WEST SUSSEX COUNTY COUNCIL CONSULTATION

TO:	Arun District Council FAO: Mr S Davis
FROM:	Highways, WSCC
DATE:	12/06/2018
LOCATION:	Land west of Fontwell Avenue, 1 Fontwell Avenue, Eastergate PO20 3RU
SUBJECT:	AL/136/17/PL Erection of pair of semi-detached houses & new access onto A29 - This is a Departure from the Development Plan
DATE OF SITE VISIT:	n/a
RECOMMENDATION:	☒ Advice ☐ Objection ☐ Modification ☐ No Objection ☒ More Information ☐ Refusal
S106 CONTRIBUTION TOTAL:	n/a

FIRM NAME ELLIS ASSOCIATES (BEXLEY) LTD 07939 129938	
CLIENT & LOCATION MS E PARKER LAND AT FONTWELL AVENUE EASTERGATE CHICHESTER PO20 3RU	
PROJECT 2'No FOUR BEDROOM SEMI-DETACHED DWELLINGS	
SCALE: 1:500 DATE: MAY 18	DRG NO: CHI/17089/P 3 OF 3

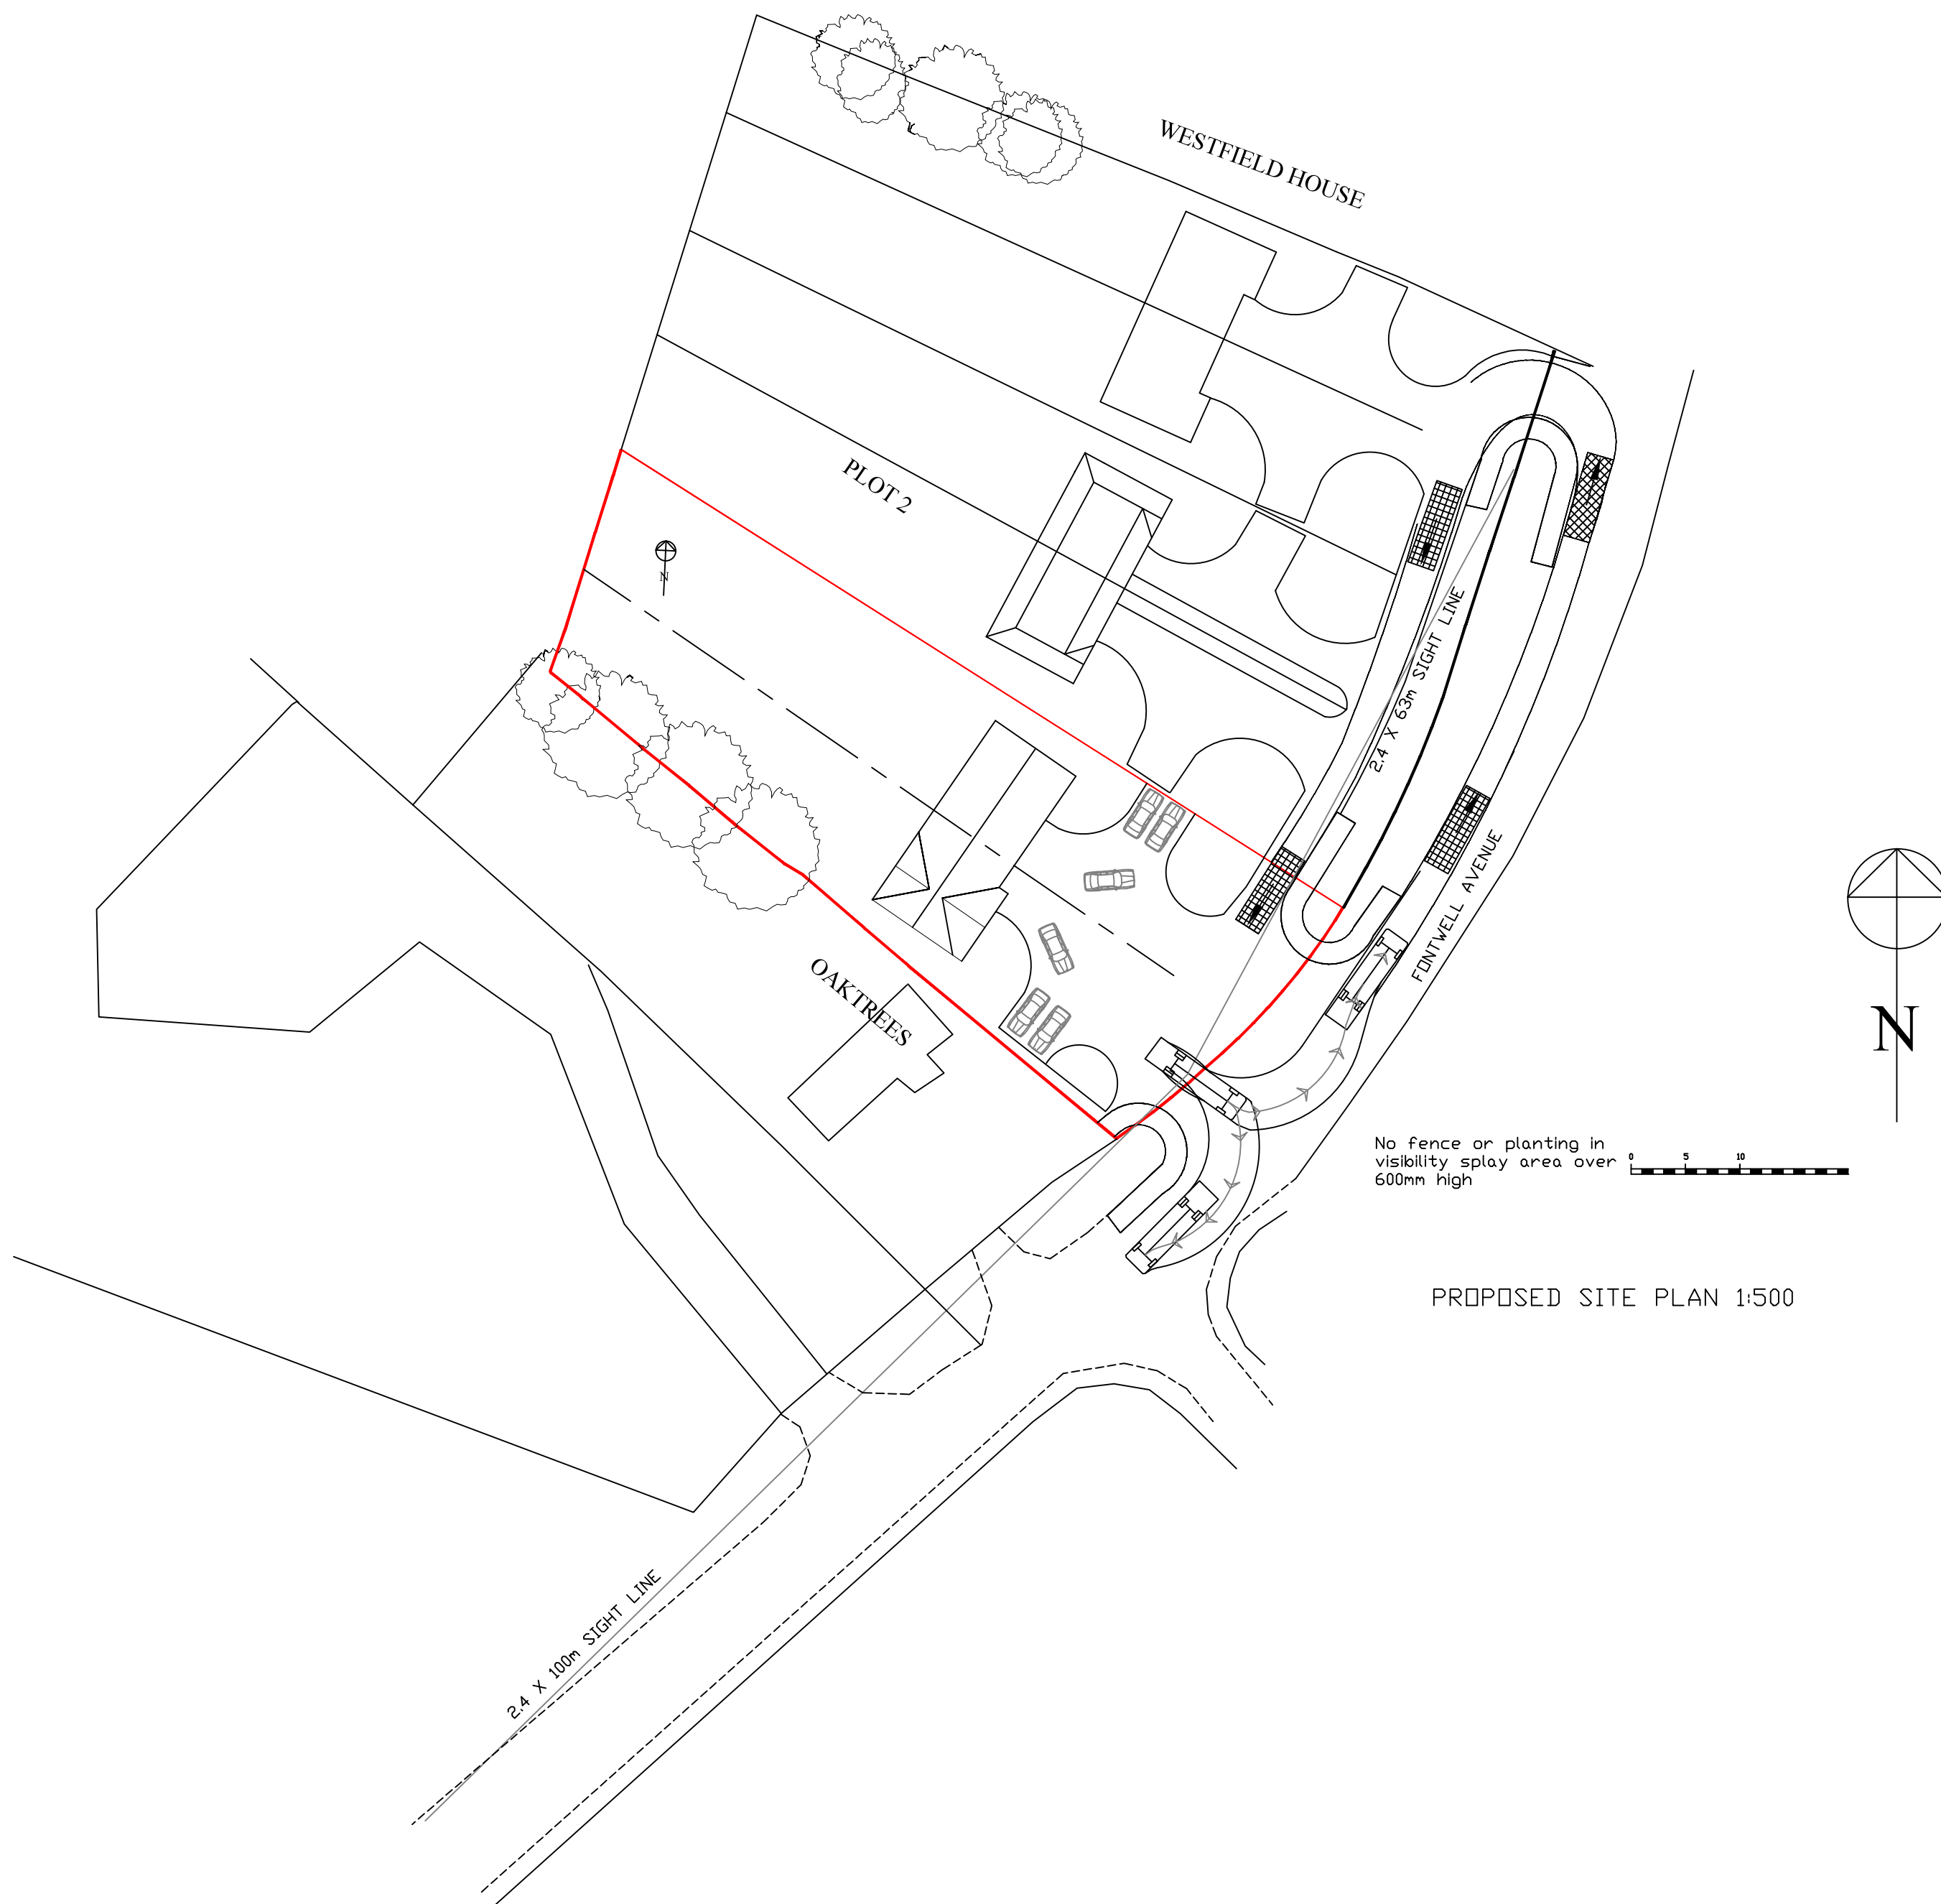
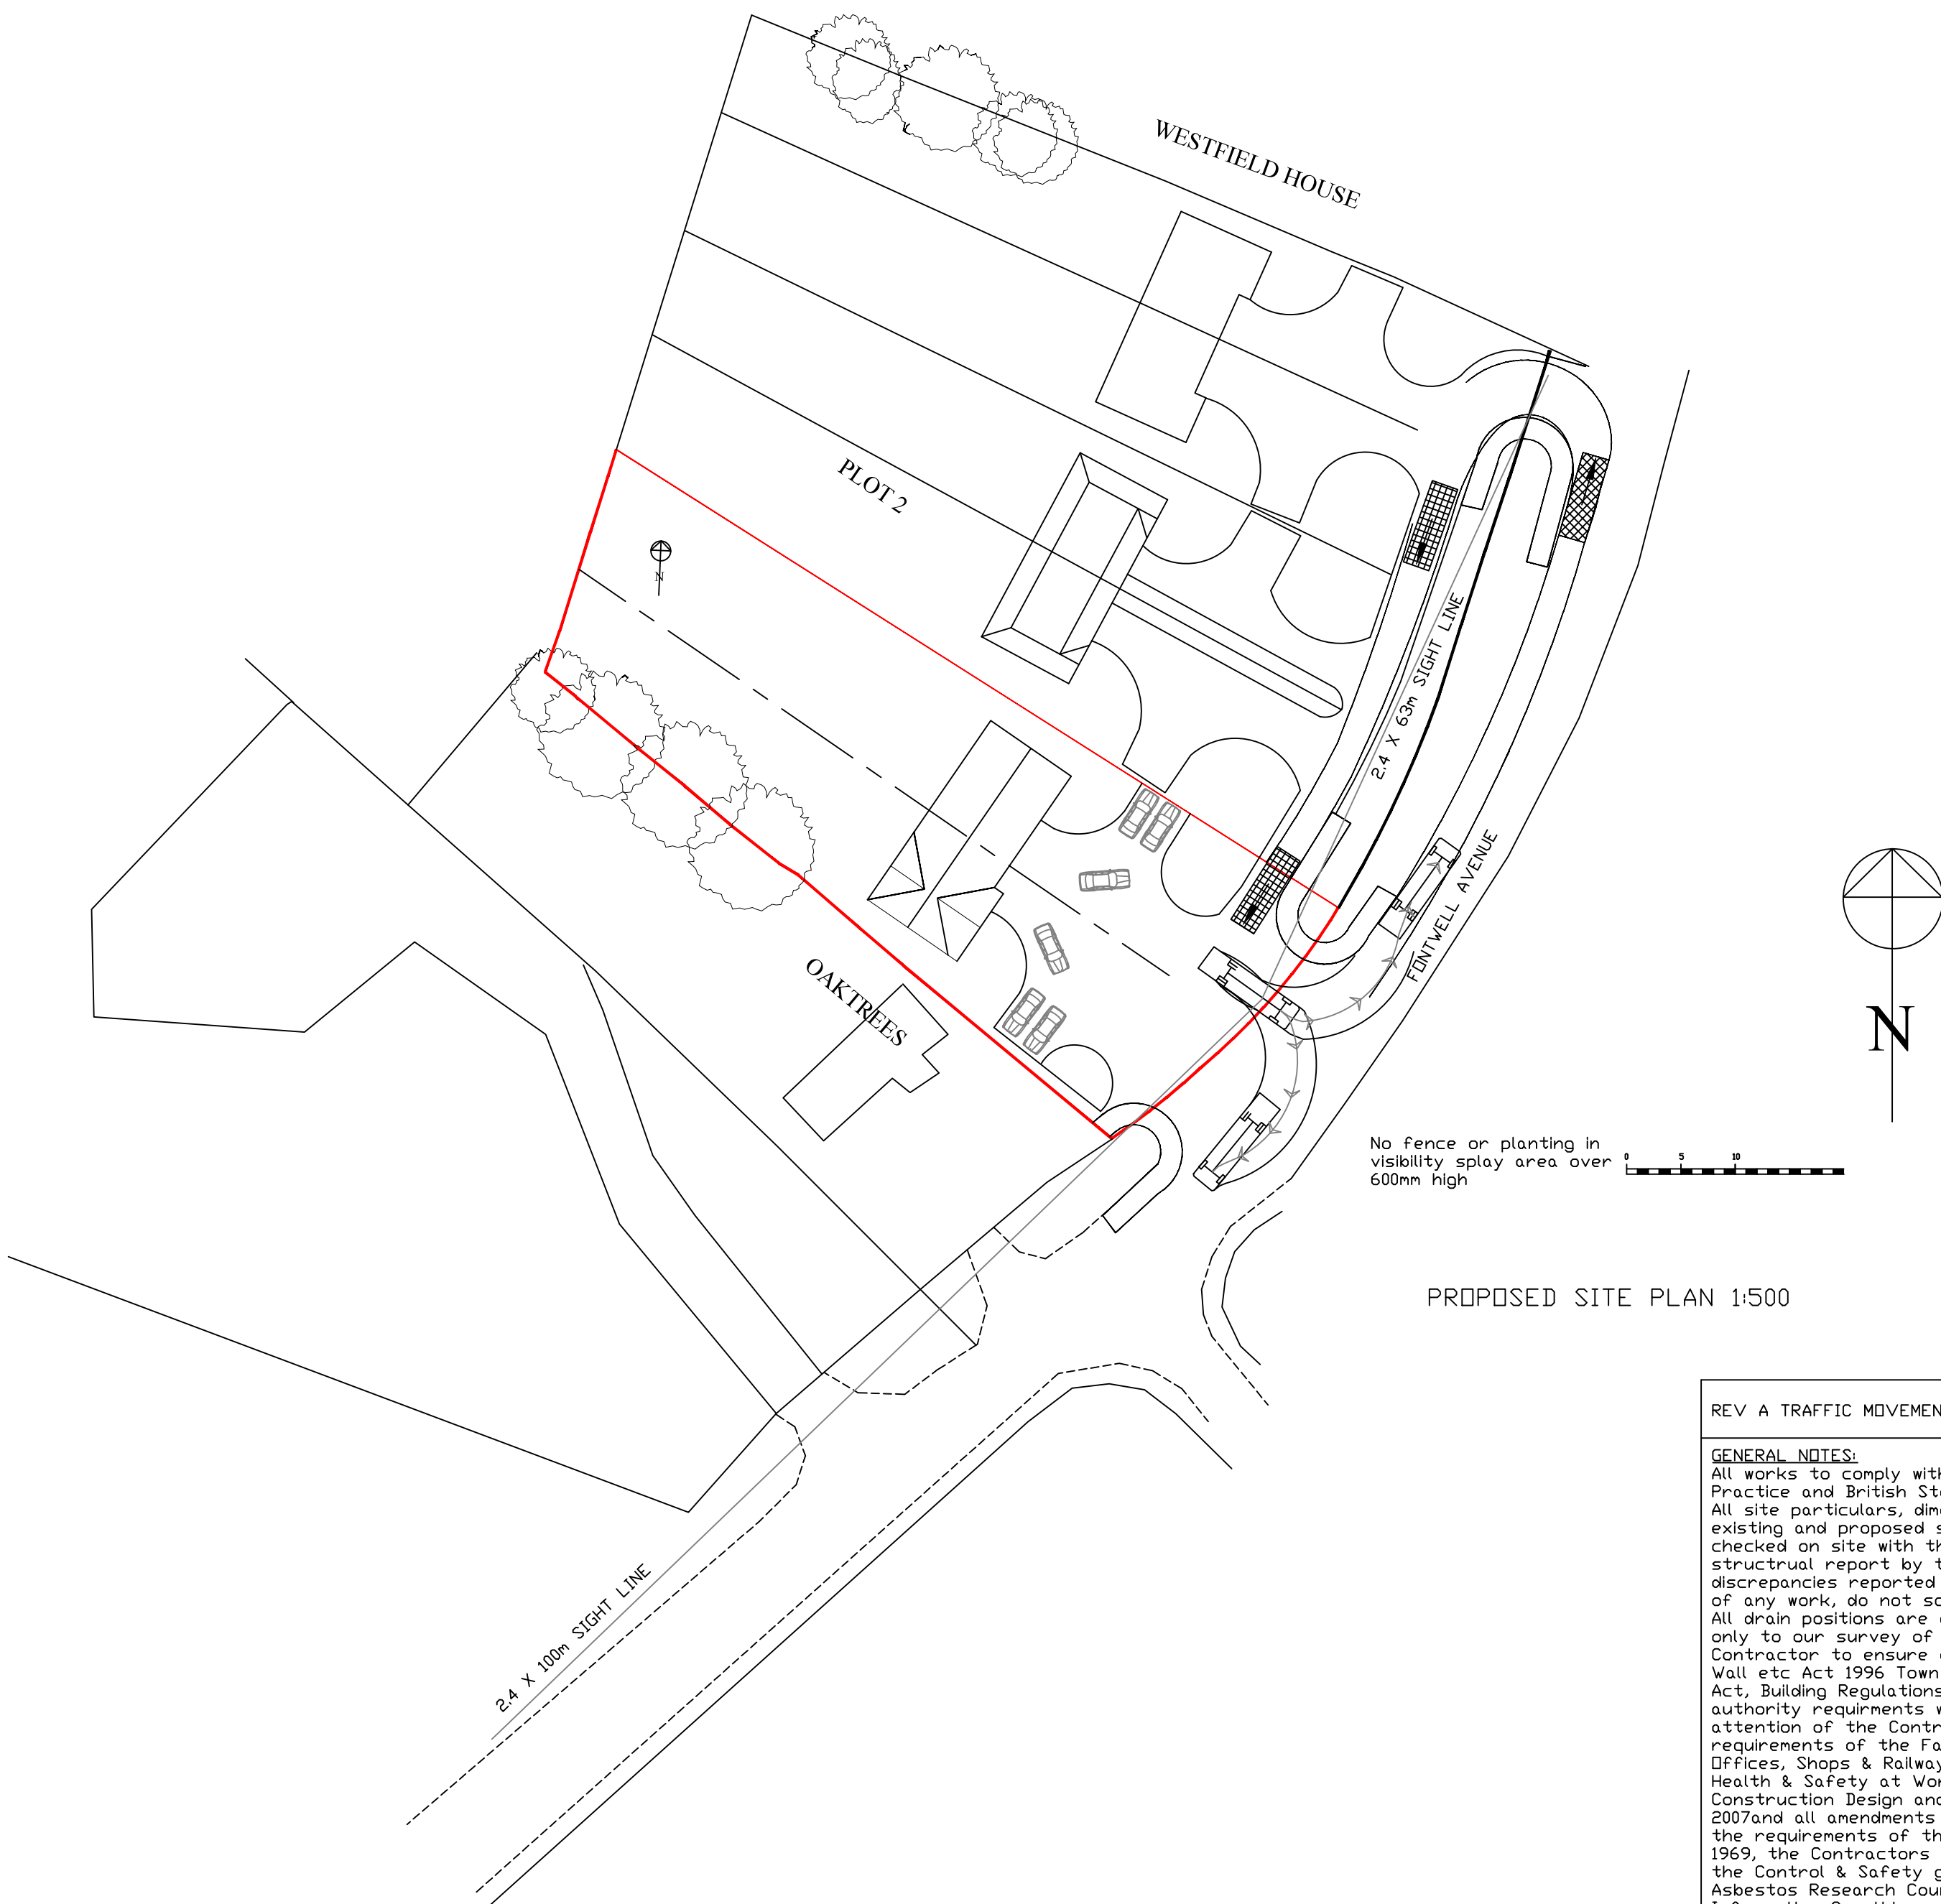
I note to the north a 2.4 x 63 metre visibility splay has been annotated on the proposed site plan. This is greater than the minimum 59 metres splay as calculated using Manual for Streets Stopping Sight Distance calculation coefficients based upon the historic speed survey data of (37.1 mph 85th percentile approach speed). This splay seems to have been drawn to the extent of the highway boundary. As previously discussed the splay can be drawn up to 1.0 metre into the carriageway.

Nevertheless the Local Highways Authority is satisfied from the plans provided that formation of an appropriate splay in this direction will require the use of 3rd party land not considered public highway. Namely a slither of land associated with plot 2.

Given the nature of this site, which seems to have been split into different plots, the applicant should provide some clarification/assurances the formation of this splay is achievable in perpetuity.

For the reasons above I would also request the splay is demonstrated correctly prior to determination.

Vehicle tracking, for what is presumably an emergency or refuse vehicle, has been provided at the proposed southern access point. However it does not show how this movement works with the proposed internal access arrangements.

This should be addressed by the applicant.

The latest plans seem to show what is a footway provision bounding both sides of the proposed southern point of access. This seems to mirror a similar provision previously secured at the northern point of access.

After inspection of the highway boundary data in this location the footway appears to extend a significant distance into the Fontwell Avenue carriageway.

Any proposed footway provision should be tied in with the existing provision, in this case the footway provision on the opposing side of Fontwell Avenue. This would require both sides to be provided with dropped crossing and tactile paving.

These matters should be addressed by the applicant.
